Appeal Decision

Appeal Ref: APP/R5510/W/23/3321565

10 Hartshill Close, Uxbridge, Hillingdon UB10 9LH

Drg. No. 22/3502/07
Scale 1:100@A3
Date 07/12/22
Drawn by KH

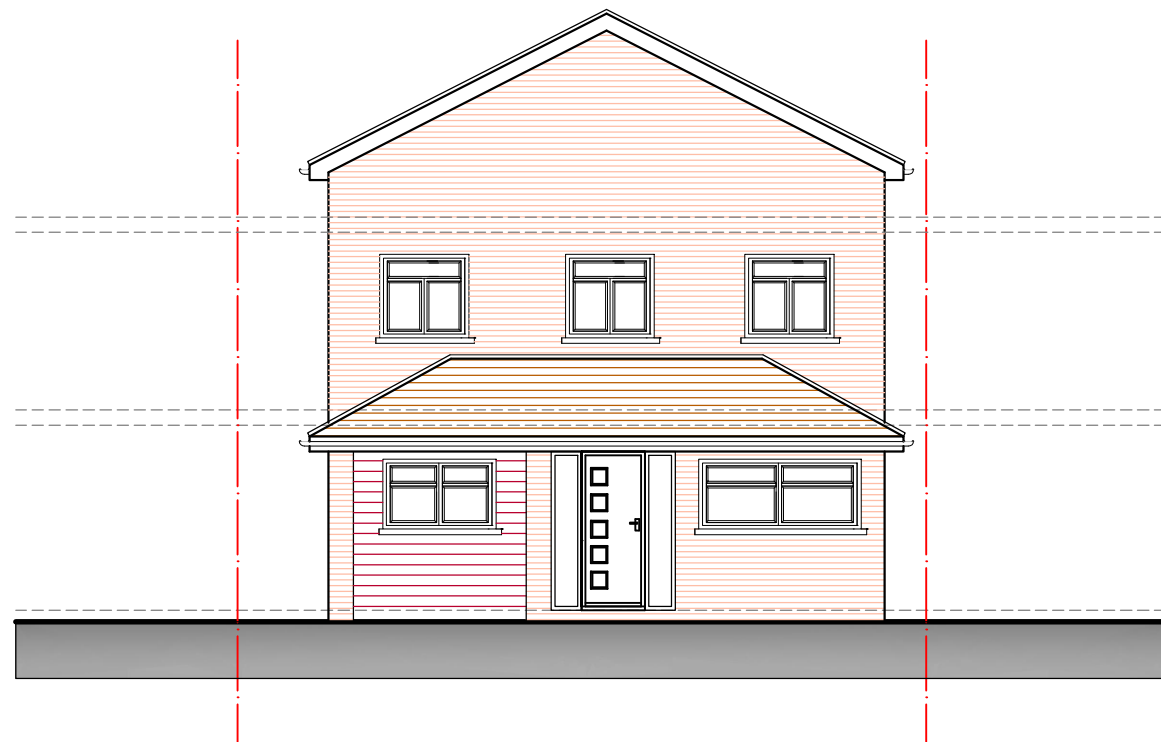
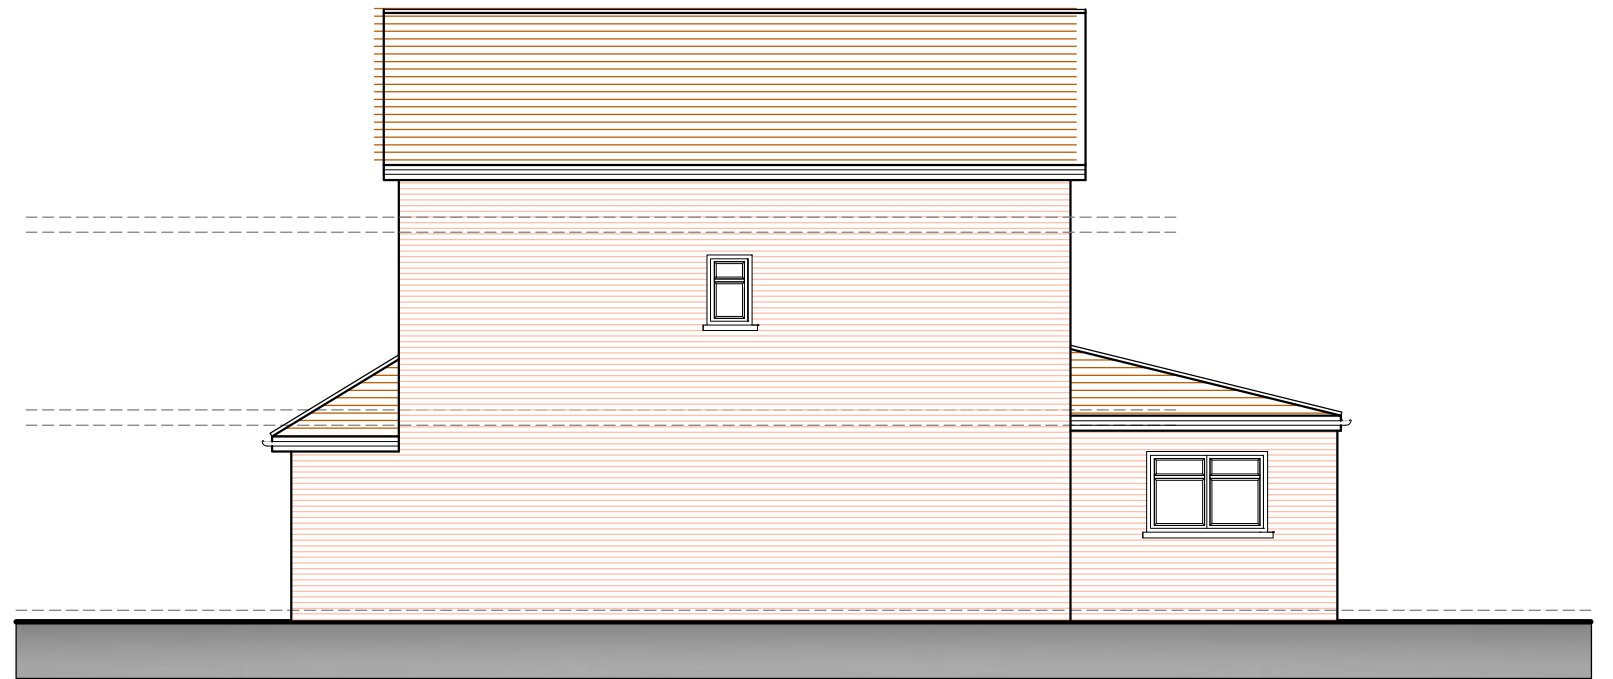
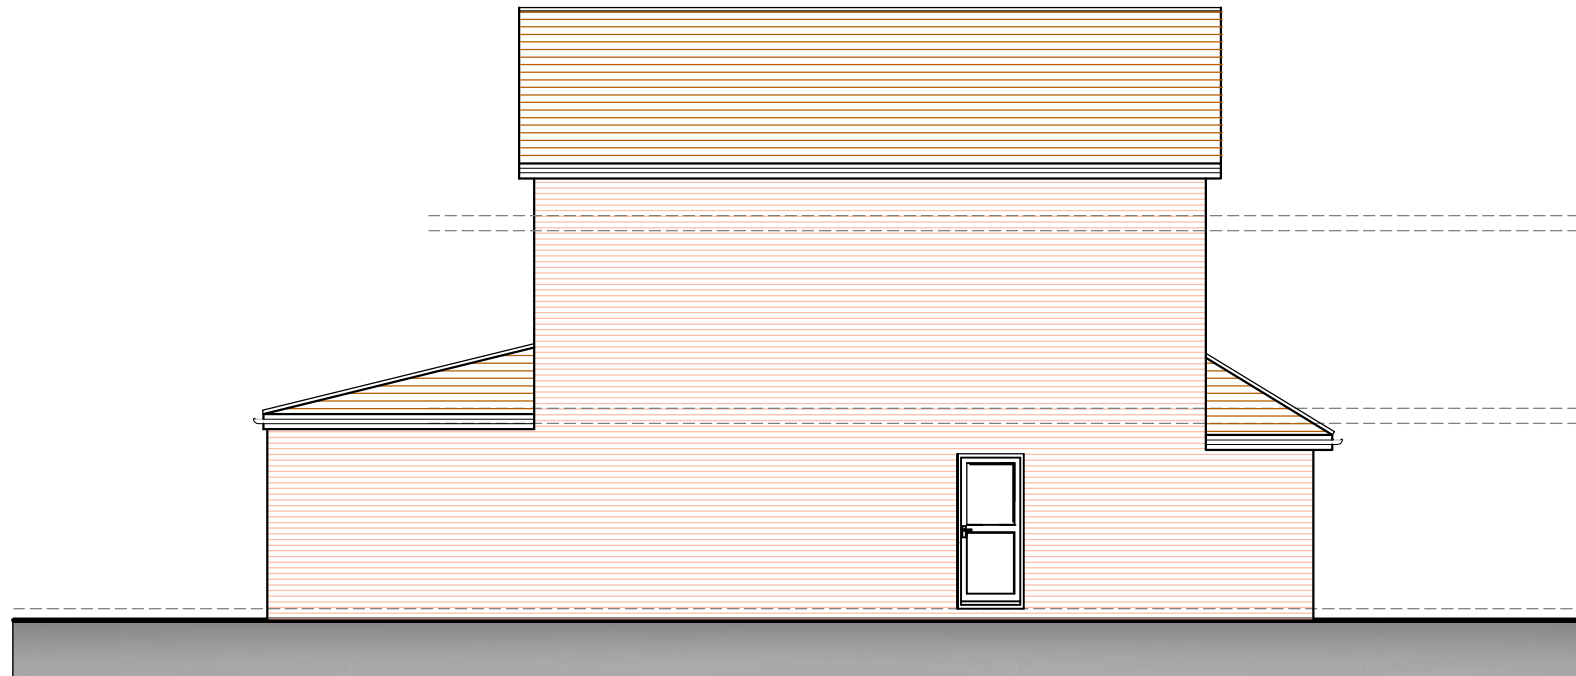
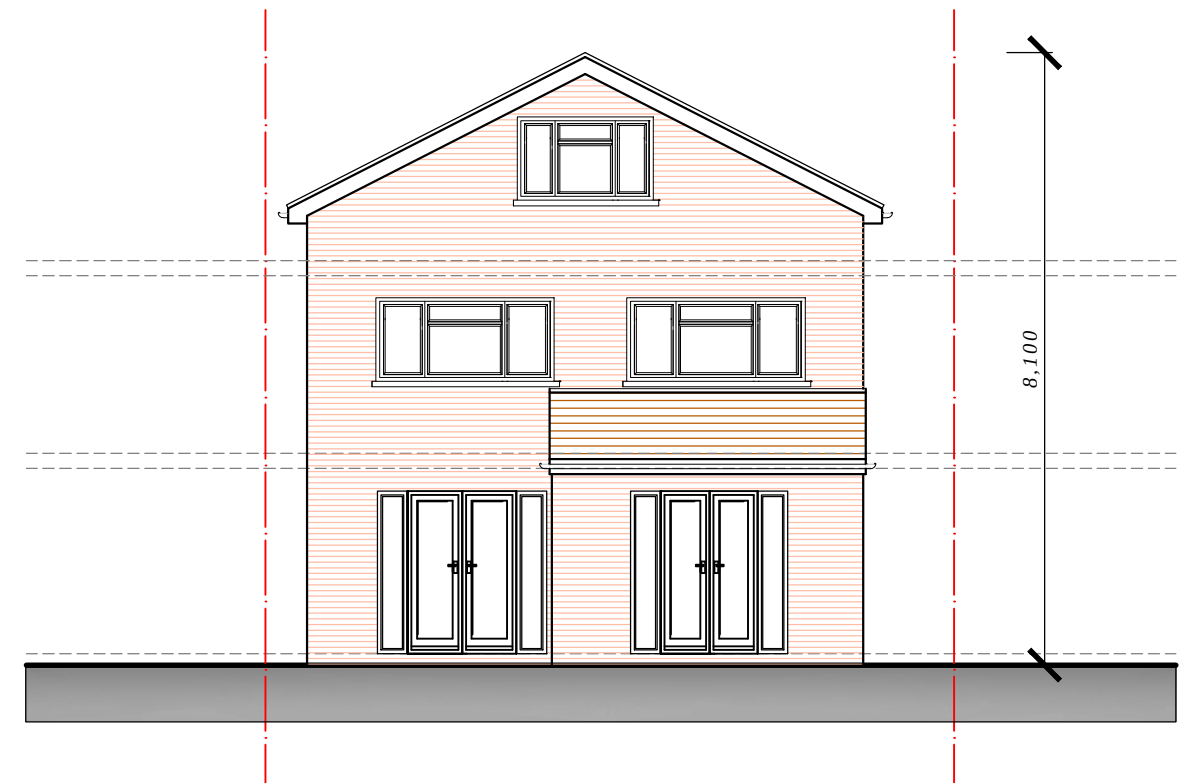
8. The proposal would raise both the eaves and ridge heights of the appeal property some 1 metres or so higher than they are currently, which would increase the amount of brickwork between the top of the first-floor windows and its eaves and ridge heights. Nevertheless, the proposal would see the same roof pitch retained and the modest increase in height would not unacceptably unbalance the appearance of the property or make it appear top heavy or particularly prominent, as it would retain its same broad form. For the same reasons, the proposal would sympathetically respect the design and architectural features of the property, including its principal elevation.

9. Whilst the proposal would make the appeal property higher than the properties nearby, including those with similar front facing gables, it would not be significantly higher. From its front elevation, there would be no openings at second floor level. In view of this, and the existing variety of the frontages of properties along Hartshill Close, the proposal would not appear out of scale with them, nor would it appear incongruous. Although there would be some effect on the regular pattern of the front facing gabled properties along this side of the road, due to the proposal's limited increase in height, and it being at one end of the line of this style of property, it would not harmfully disrupt this symmetry, when viewed in either direction along Hartshill Close.

13. In this case there are 2 no. existing bedroom windows on the rear elevation of the appeal property that already allow a degree of overlooking at oblique angles towards the gardens of the adjoining properties. The proposed second floor bedroom window would be above the existing first floor bedroom windows and would allow a similar level of overlooking also at oblique angles of the adjoining objector's garden. In view of this, the level of potential overlooking towards the objector's rear garden would not be materially different to the existing situation or be harmful to the living conditions of the adjoining occupiers. Consequently, I am satisfied that allowing this appeal would not unacceptably violate the nearby occupier's rights under the HRA and would be consistent with my PSED duty contained in Section 149 of the Equality Act 2010.

Drg. No. 22/3502/06
Scale 1:100@A3
Date 07/12/22
Drawn by KH

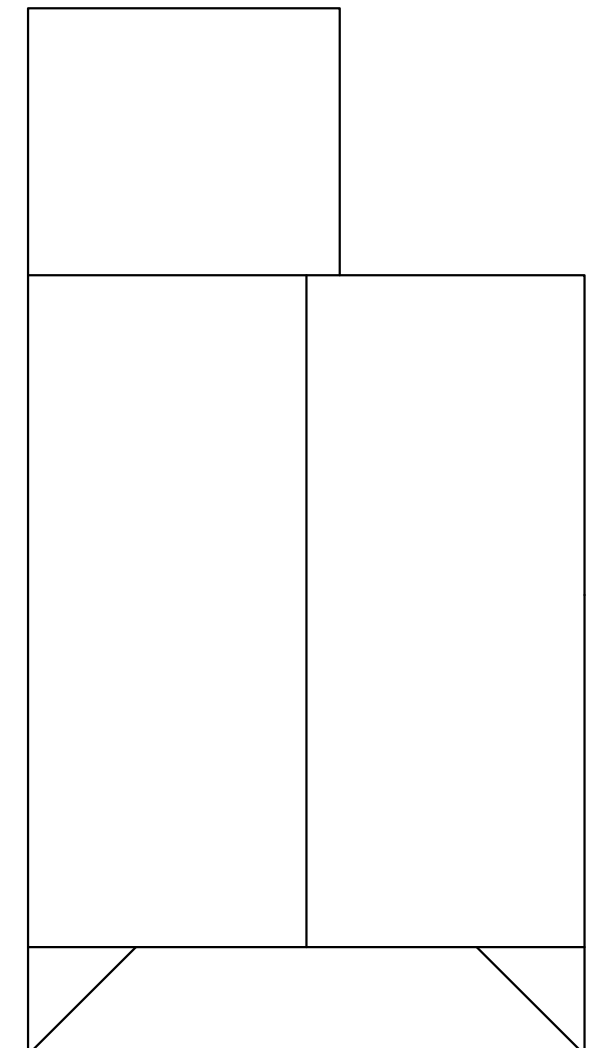
15. It has been suggested that an internal door height on the appeal proposal at second floor level would be very low. Notwithstanding whether the proposal would comply with Building Regulations, which are separate regulations, this is
